BRITISH HORSE SOCIETY – BEDS – COMMENTS ON DRAFT ASI ITINERARY (REP1-065)

At Deadline A, the BHS requested that the ExA visit Pertenhall BW26 and Bolnhurst & Keysoe BW37, identifying a number of points for the ExA to consider:

Figure 2-4 Proposed Site Access (Rev P01)

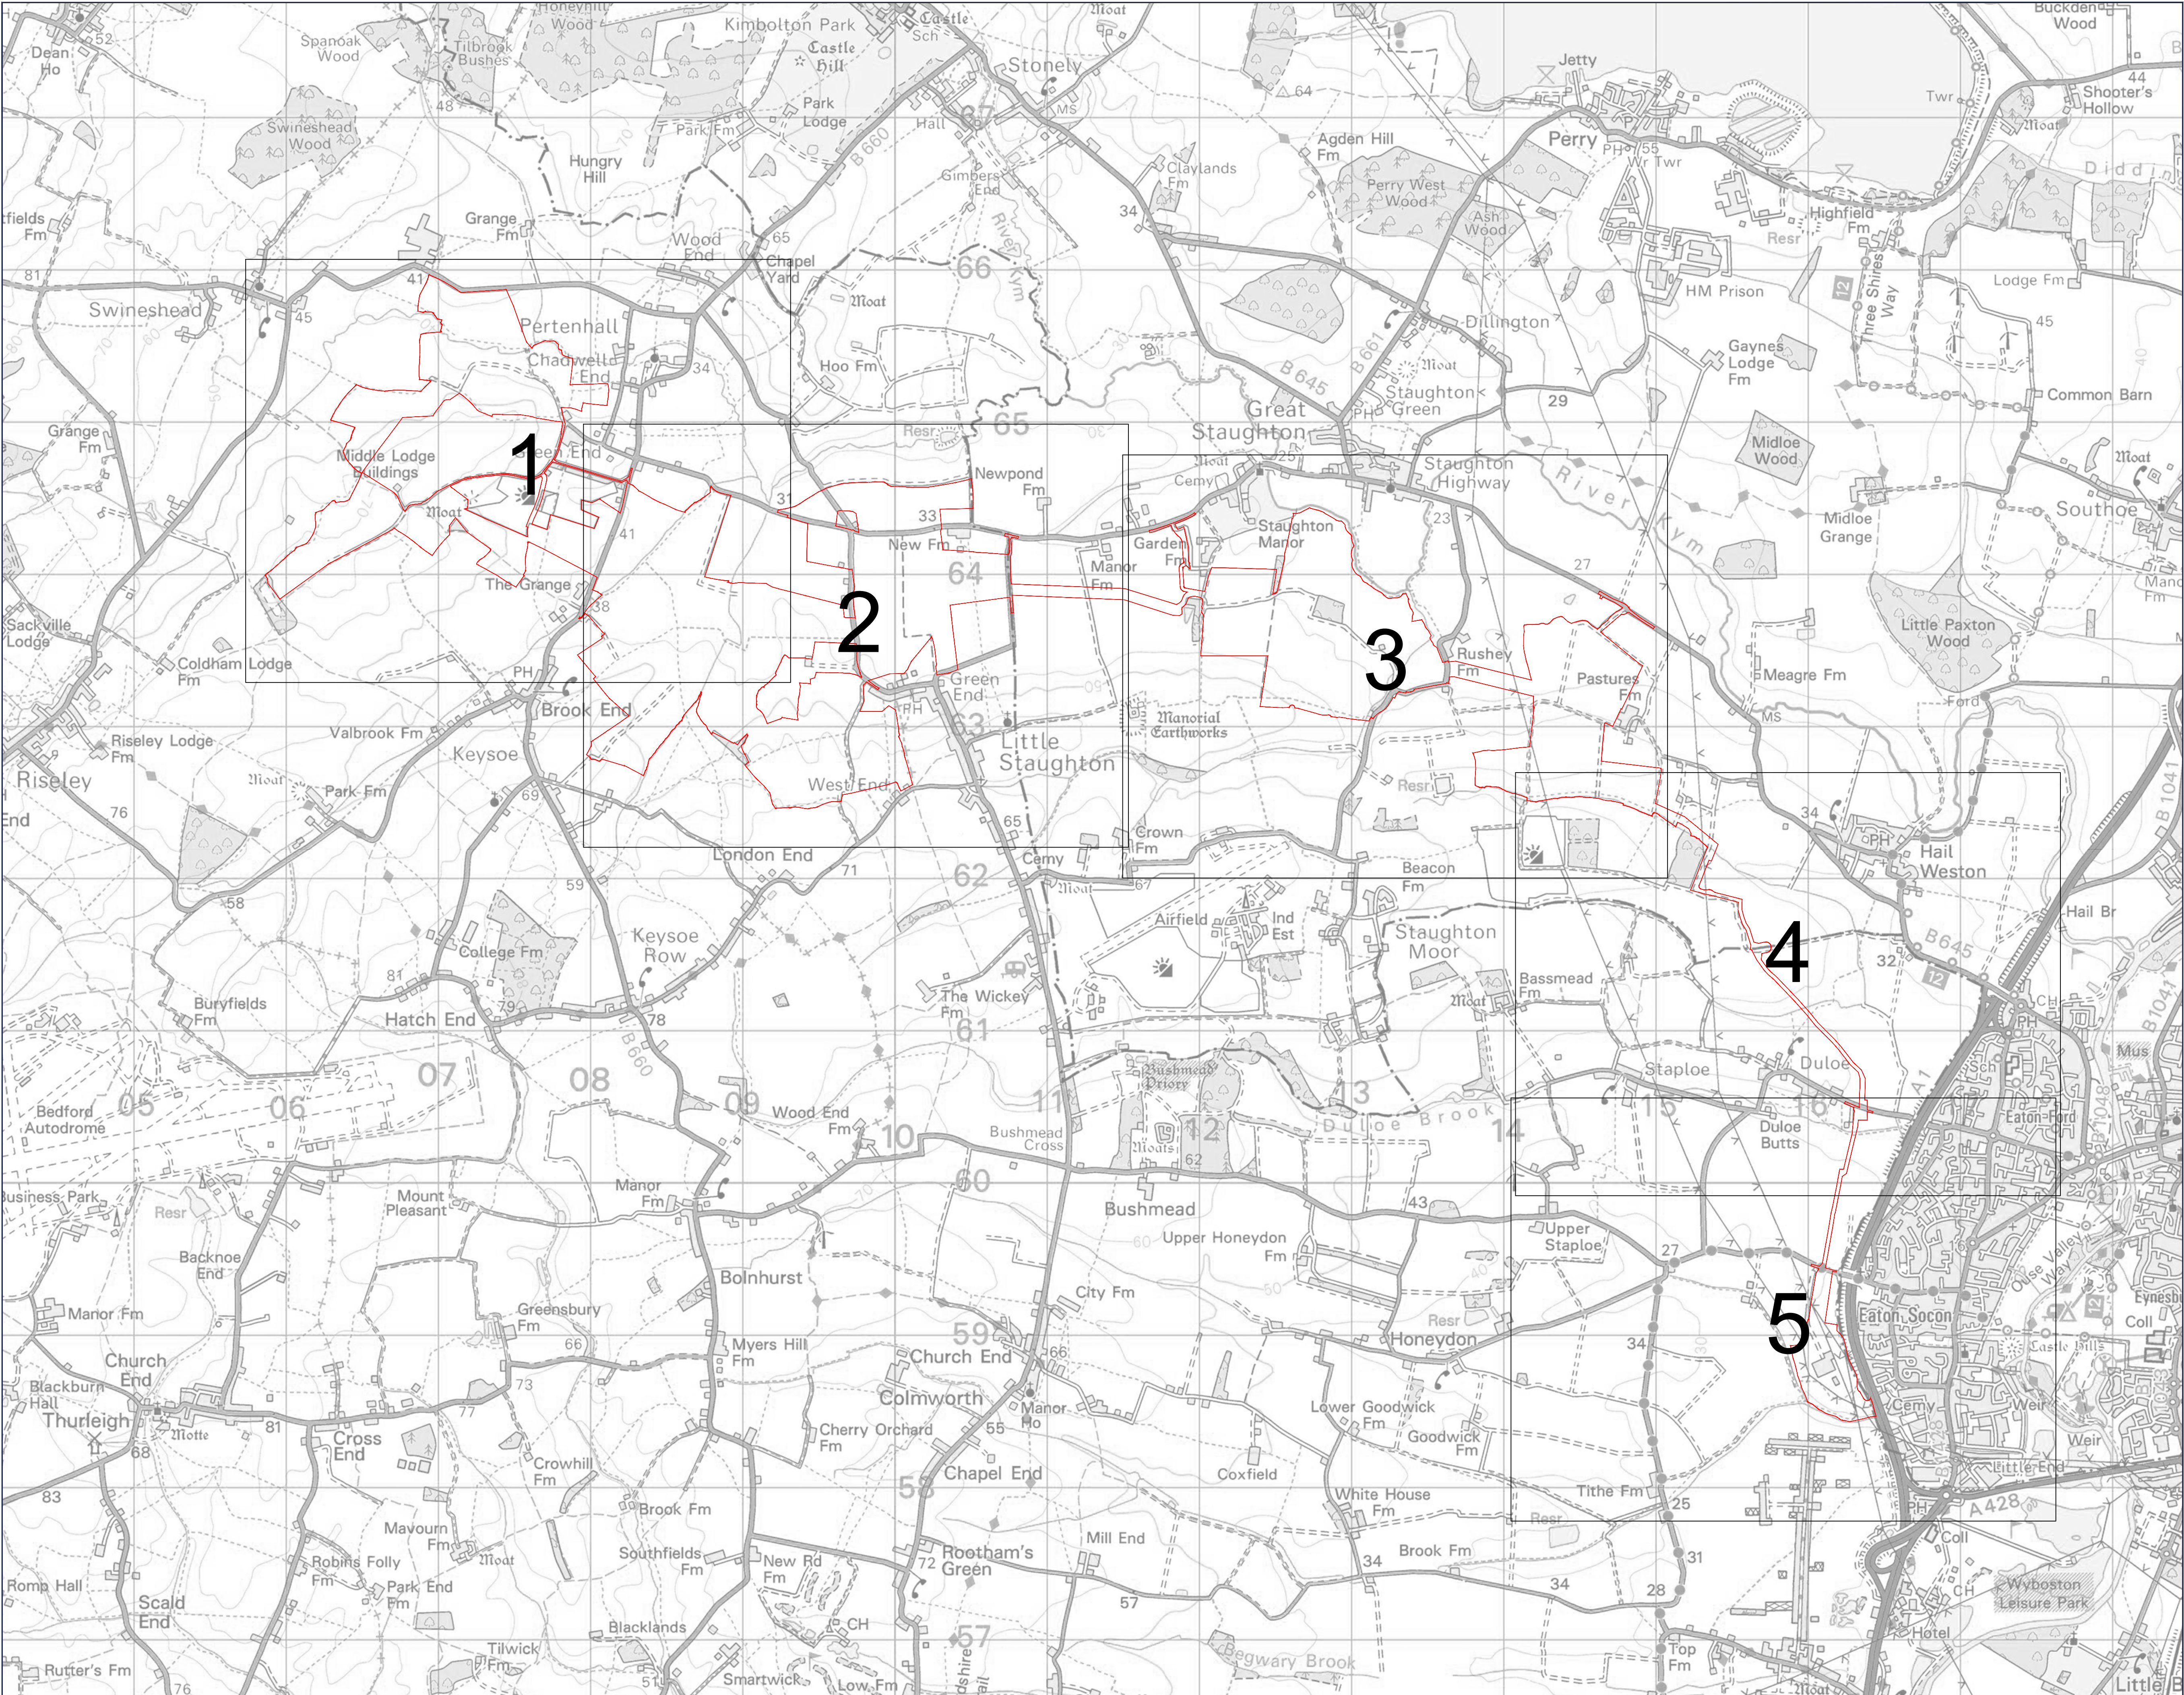
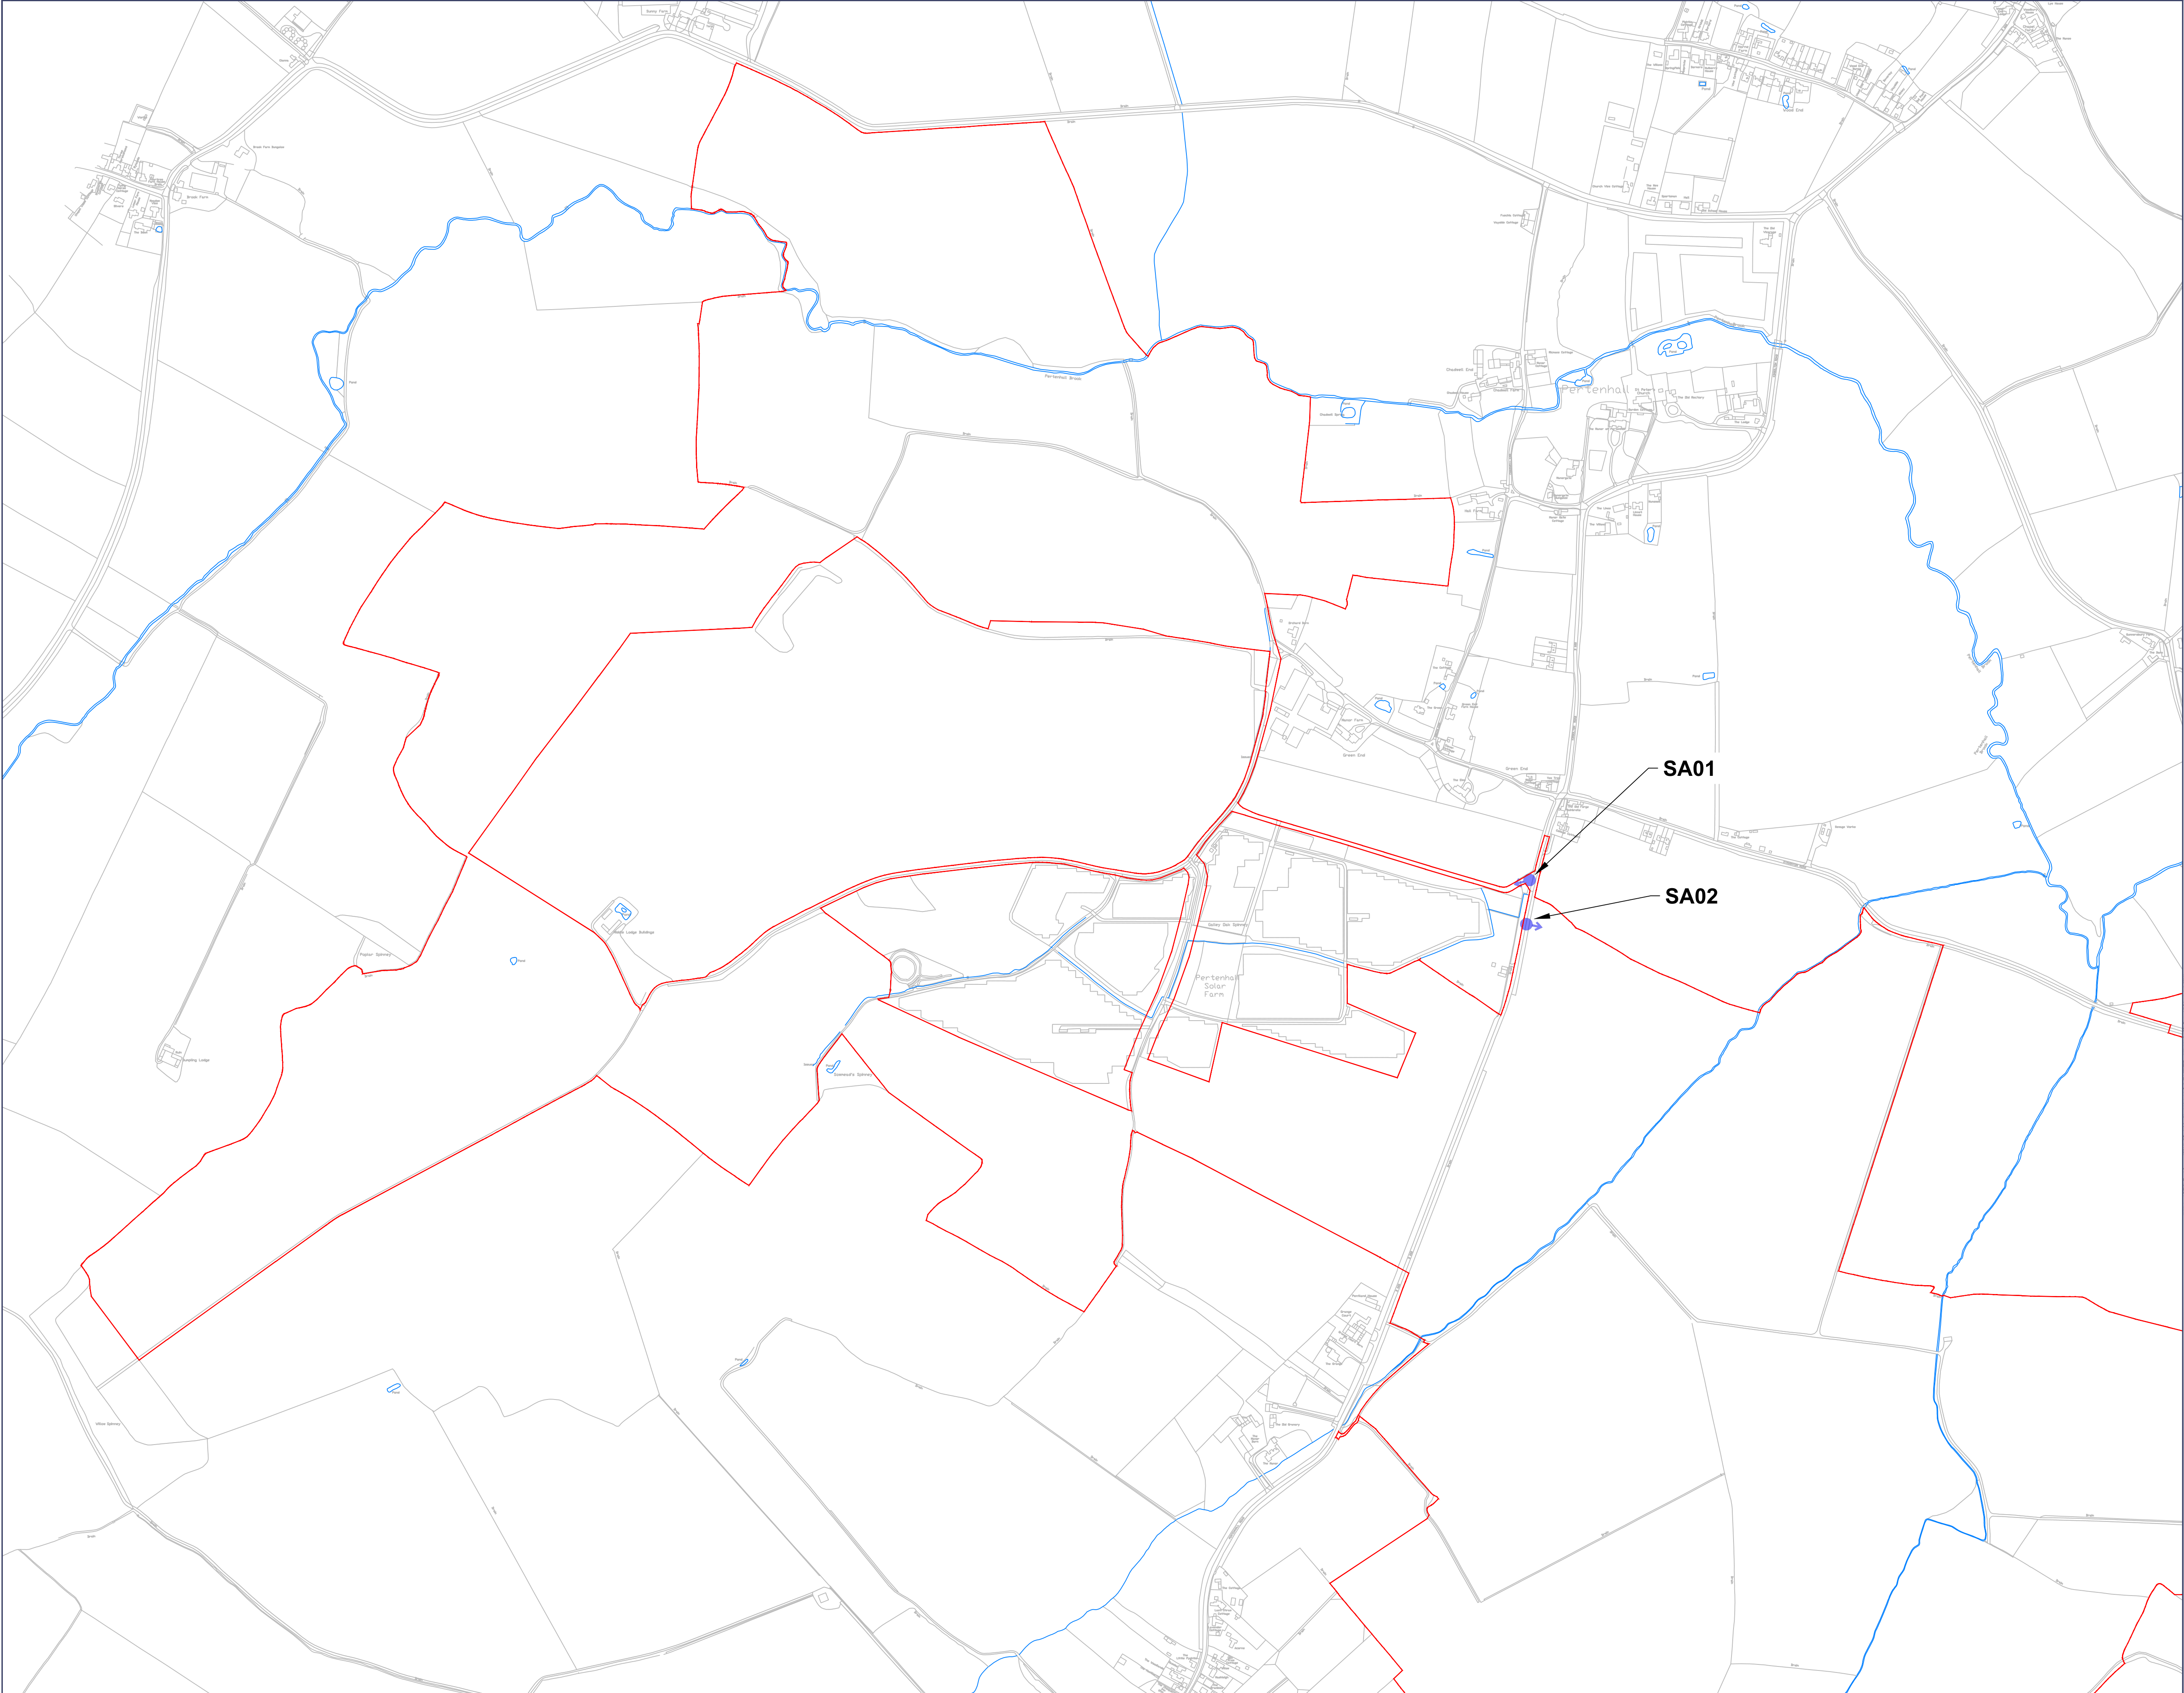
Between C and D, the Justification column of the itinerary refers to SA12 but not to the site access just before D, which curiously is not labelled on the Site Access plan (APP-124).

Likewise, the itinerary justification between D and E should refer to SA05. And the route should be extended to visit SA03.
